REVISIONS: Comments: 03.16.22
 THIS DRAWING SHALL NOT BE COPIED, REPRODUCED, OR TRANSMITTED IN ANY FORM OR BY ANY MEANS, ELECTRONIC OR MECHANICAL, WITHOUT THE EXPRESS WRITTEN PERMISSION OF THE ARCHITECT.
NDS NATURAL DESIGN SOLUTIONS
 Landscape Architecture
 Land Planning - Irrigation Design
 5535 East Drive, Longmont, CO 80503
 (303) 449-0058 - info@ndslandscape.com
GRAHAM STORAGE - LATIGO BUS CENTER, FILING 1
PEYTON, CO
FINAL LANDSCAPE PLAN
 PROJ. NO.:
 DATE: 11.30.20
 SCALE: See Sheet
 DRAWN: JRO
 CHKD BY: NAM
 SHEET L10
 PCD FILE NO: PPR 2010

**GRAHAM STORAGE - LATIGO BUS CENTER, FILING 1
PEYTON, CO**
FINAL LANDSCAPE PLAN DETAILS & NOTES

### LANDSCAPE PLAN

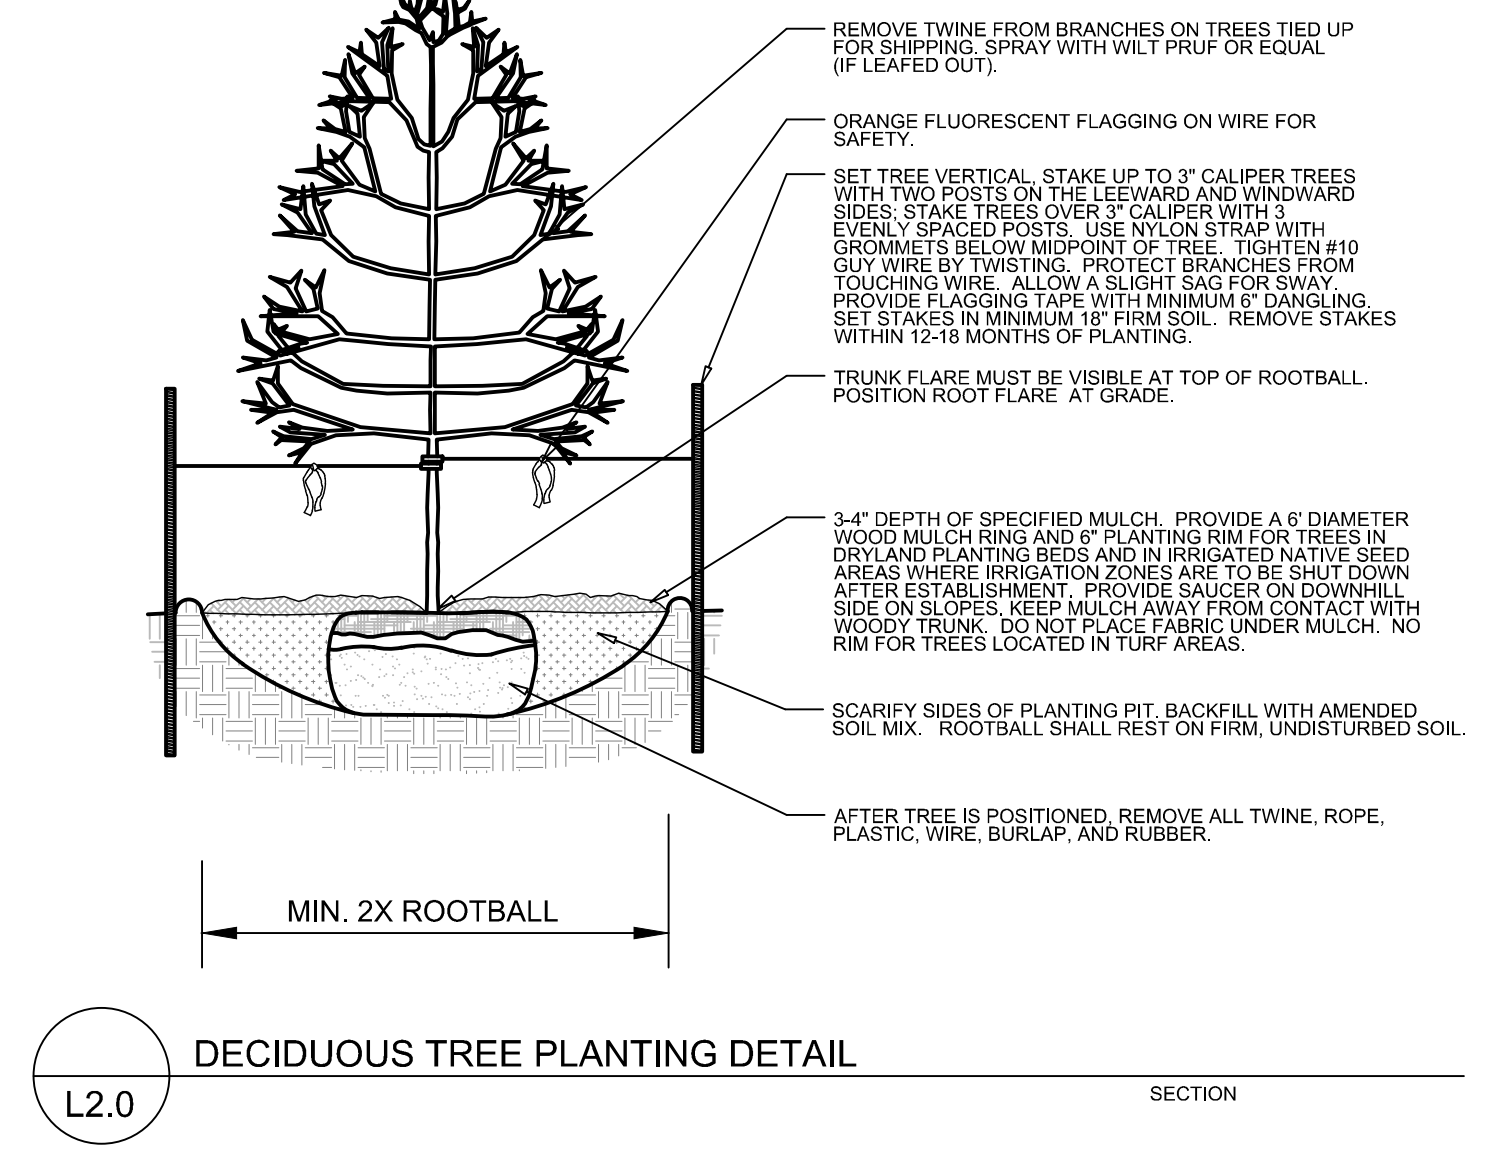
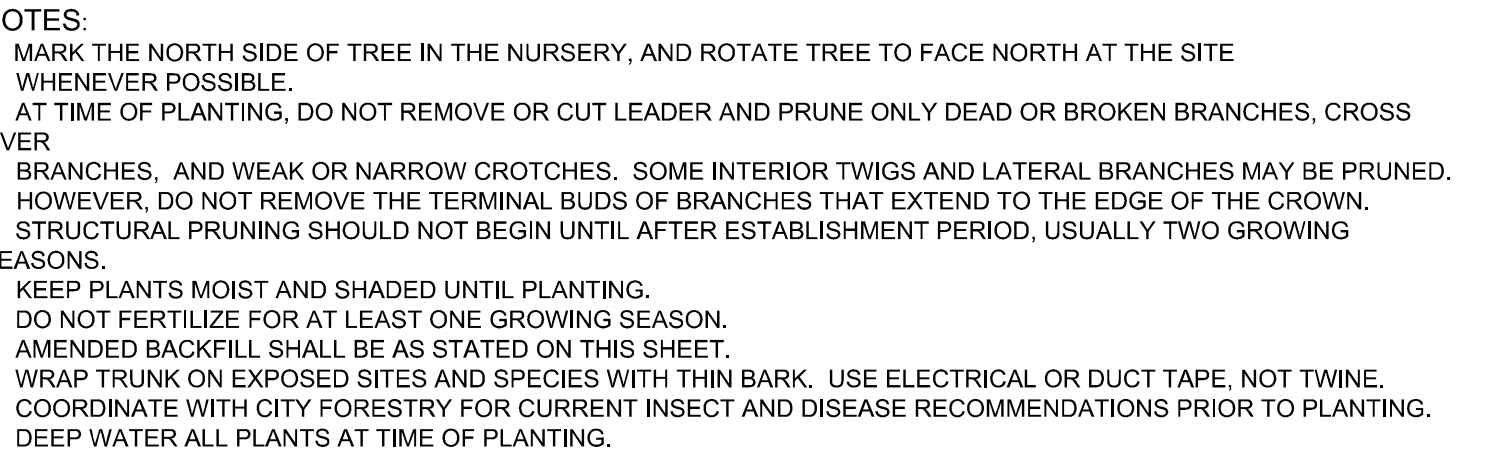
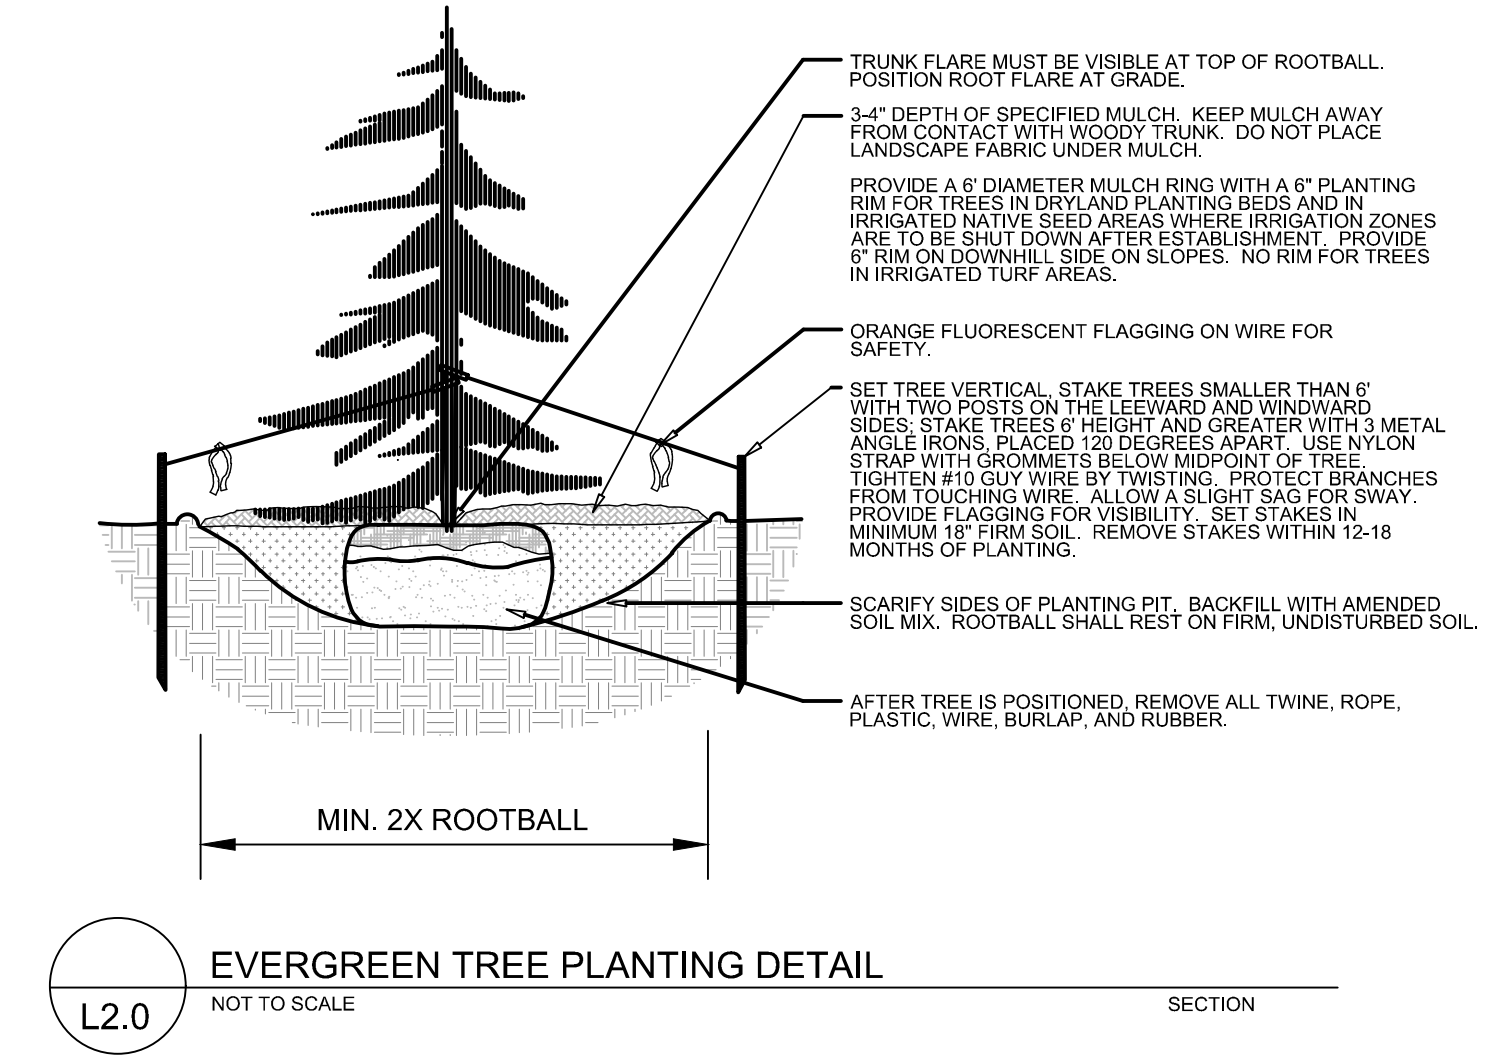
Please remove/relocate the proposed trees that are within the ROW. Per ECM 2.5.8 Landscaping must be easily maintained by the use of power mowing equipment. Prior written approval from the ECM Administrator is required for plantings in the ROW.

-Please depict owner or applicant: email, number, and name
 -Please provide a vicinity map on the landscape plan
 -Please show location and dimension of all property lines, rights-of-way, and all existing or proposed easements

-Please provide information on screening for the parking lot

-Please depict surrounding properties zoning
